From:
To: [DCAdmin](#)
Subject: Objection Letter - 2021/91914
Date: 06 January 2022 08:49:45

Planning Application at 28 Northorpe Lane, Mirfield. Application number: 2021/91914

Proposed Site Layout

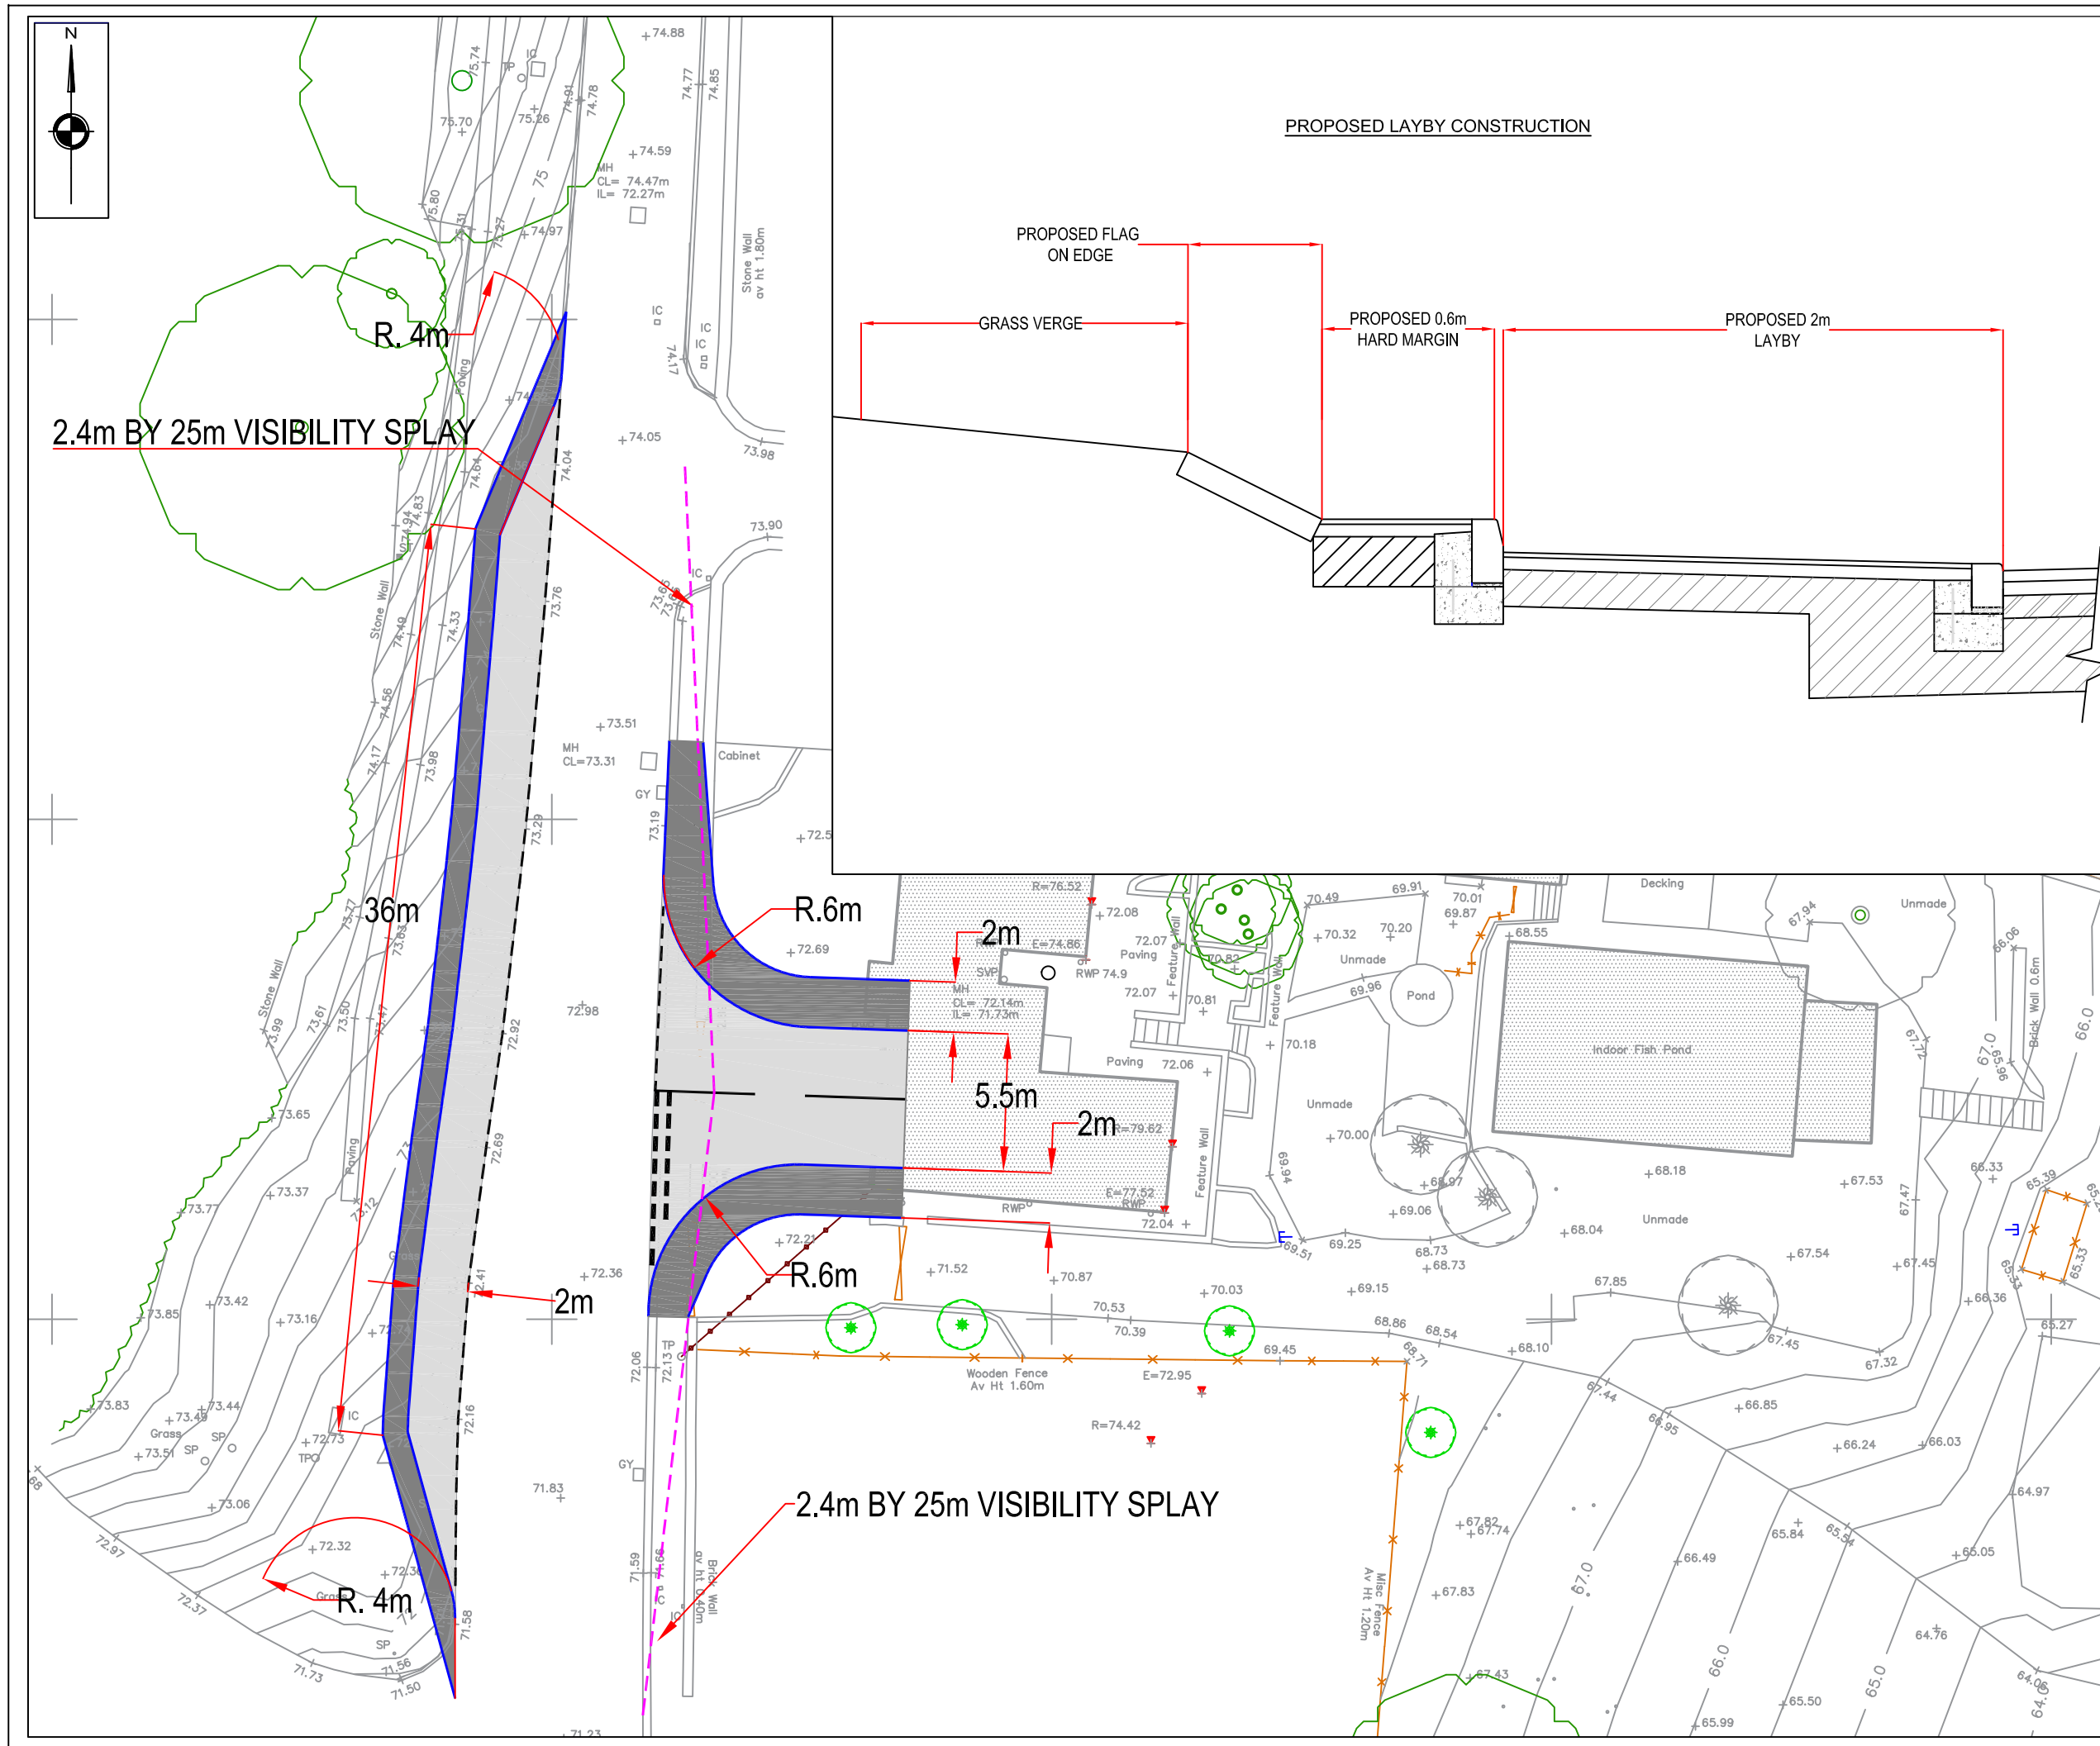
The density of the proposed development is still too high and not appropriate for this location. The design of the new houses does not reflect the local architecture, character or housing mix of the neighbourhood and is not appropriate. The new plans show the houses closer to the existing homes on Northorpe Lane, so the proximity of the new units will have a huge detrimental impact on us. The inclusion of three storey houses does not reflect existing housing design in this location and the scale of these taller houses will over-shadow the existing homes.

Removal of the green from Northorpe would breach the Council's own policies on protecting green spaces and heritage assets. The new plans show that the green space that was being provided for this estate no longer exists and it must therefore be the case that the Green on Northorpe Lane is even more important to protecting the character of the community and the well-being of the residents. You have a policy that green spaces should be protected but you want to destroy this one so that the builder can have this site. How can that be right? There has been no assessment of the impact this development will have on the existing community in terms of noise and nuisance during construction. Although an assessment confirms that there are no issues with noise that would affect the NEW dwellings it does not take into account the effect the new estate will have on the existing residents. A prolong building period and thousands of delivery vehicles coming to and from the site will have a massive impact on the quality of life of residents and on road safety. This has not been mentioned.

Drawing:
**KIRKLEES REFUSE VEHICLE
SWEEP PATH ANALYSIS**

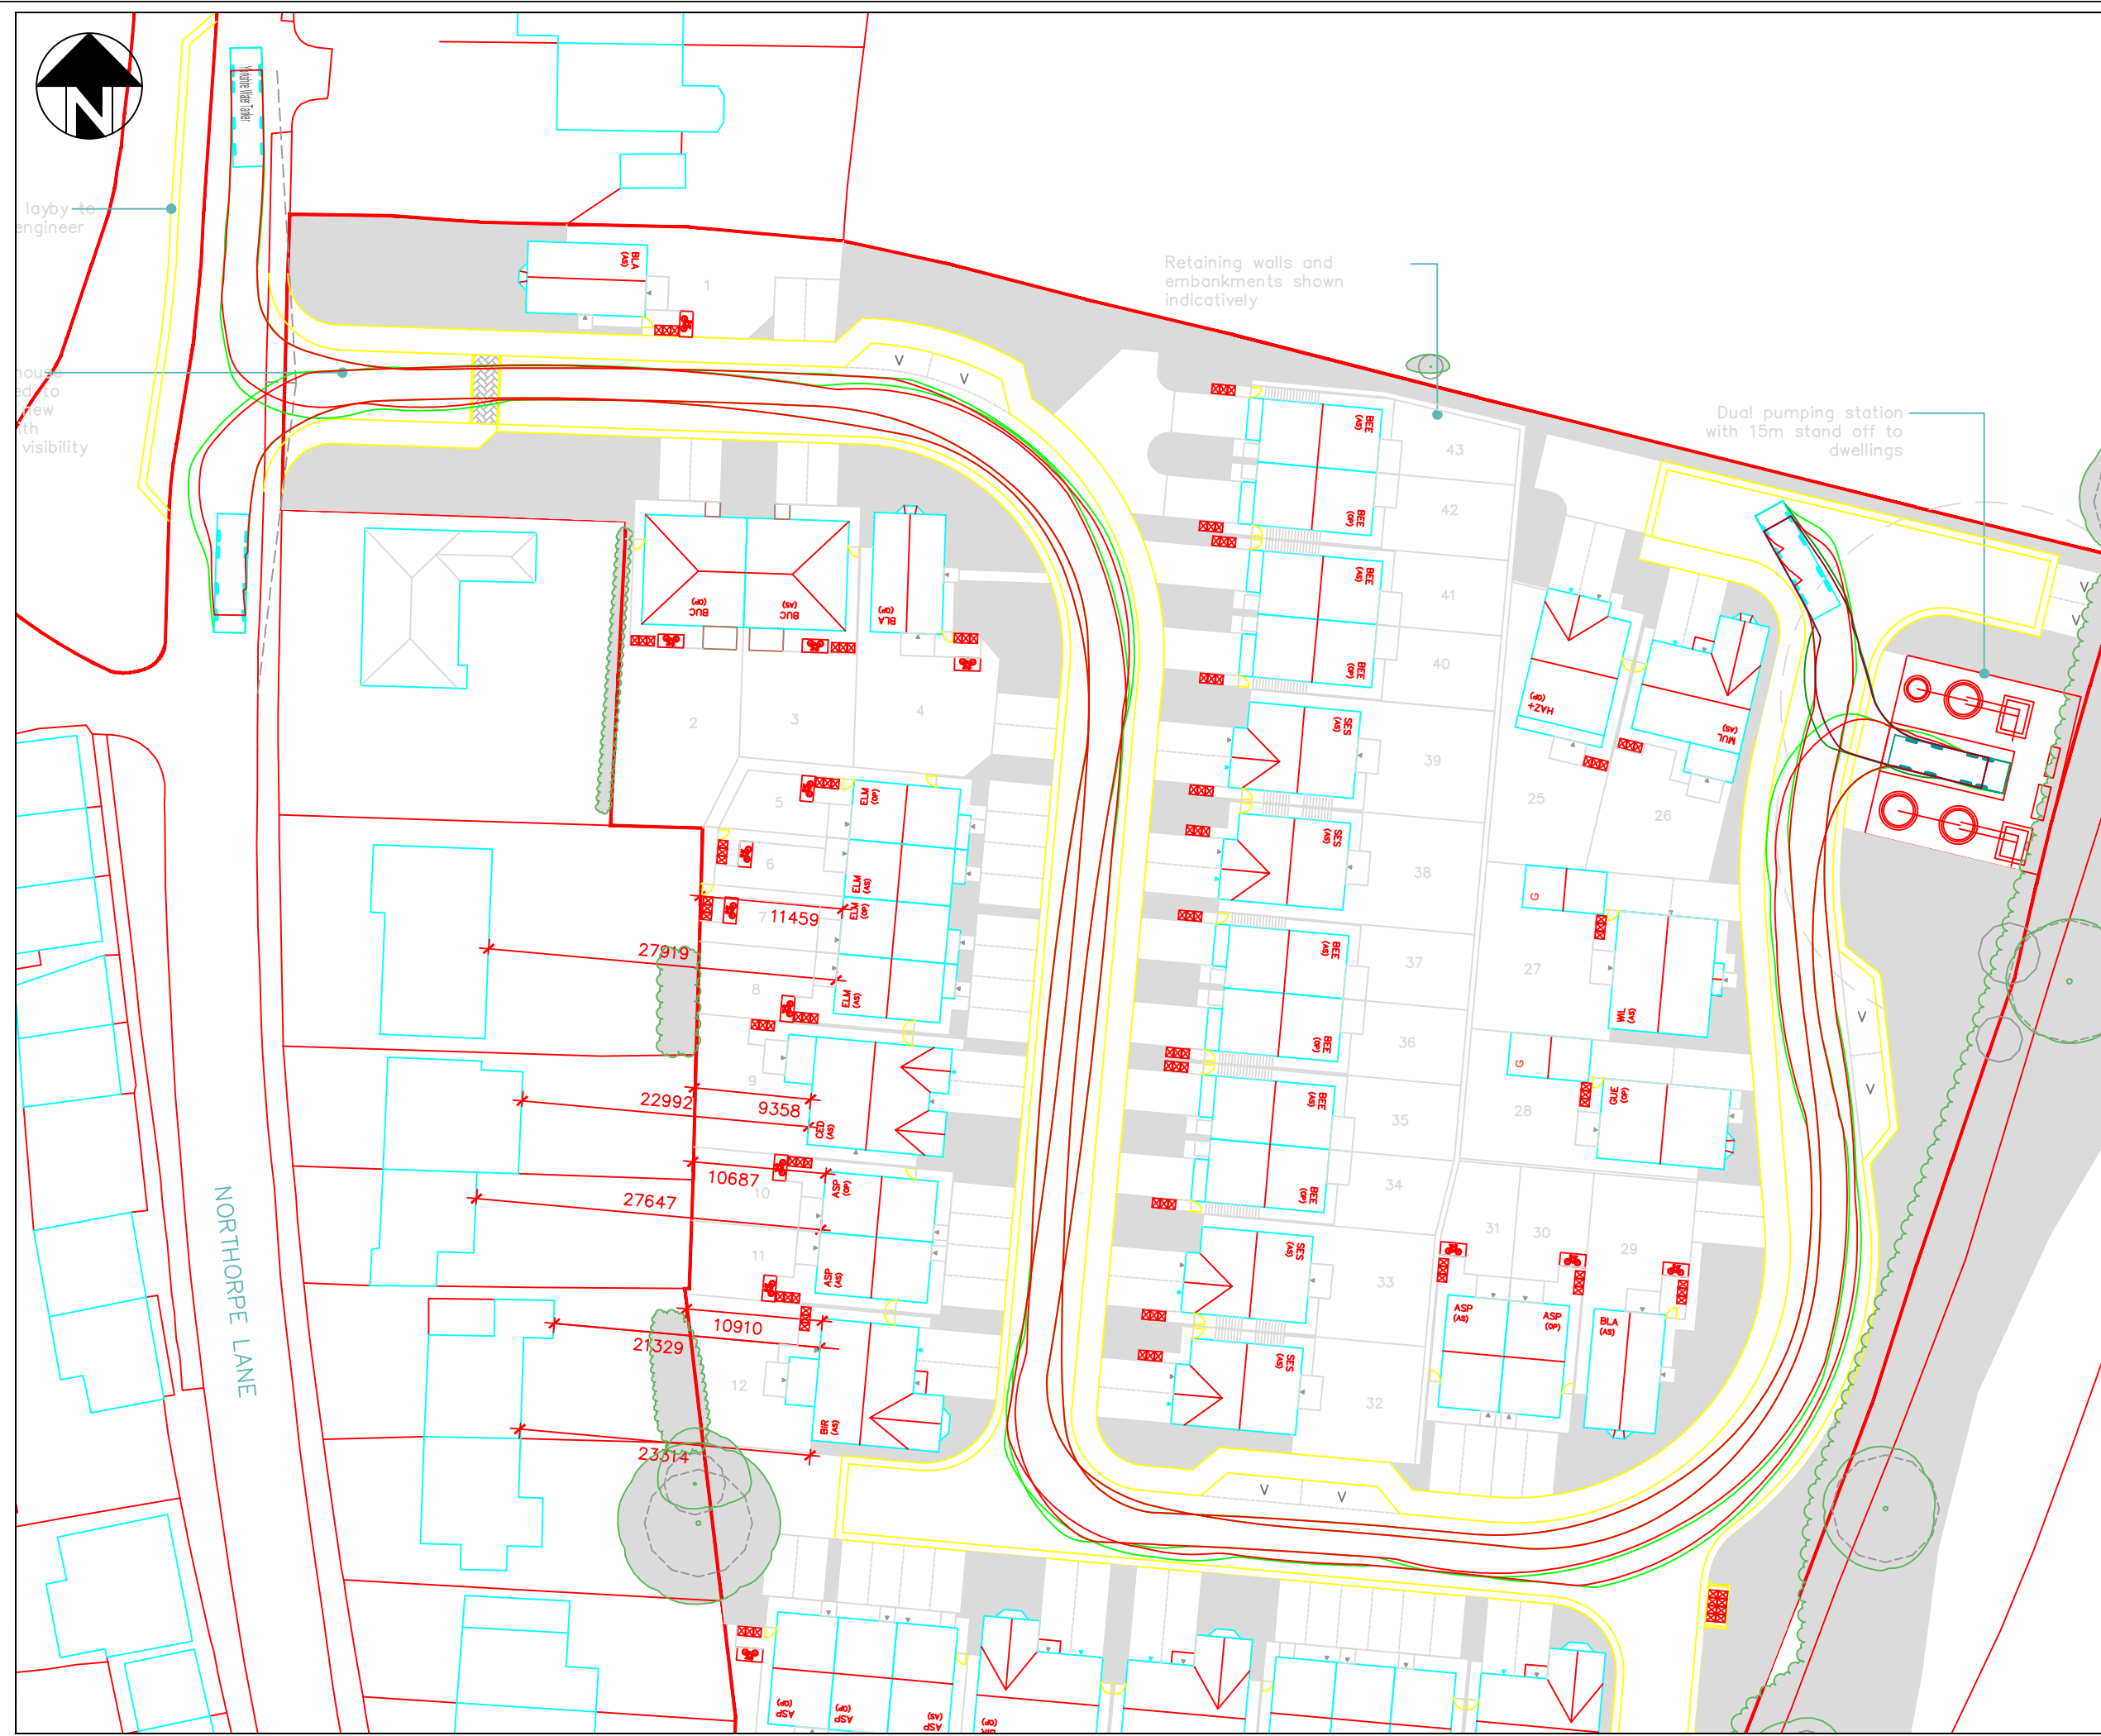
The majority of problems with this site have not been resolved so it is difficult to see how there are any changes from the previous situation. Kirklees Council has no rights to use the land at Northorpe Hall to build a layby. This land is owned by Northorpe Hall and does not form part of the public highway, as shown by a detailed investigation into the legal status. The Council has provided no evidence to disprove and without the layby, you have already acknowledged that the entrance to the new site would not meet highway requirements. Therefore, for this reason the scheme is not acceptable and the application should be refused.
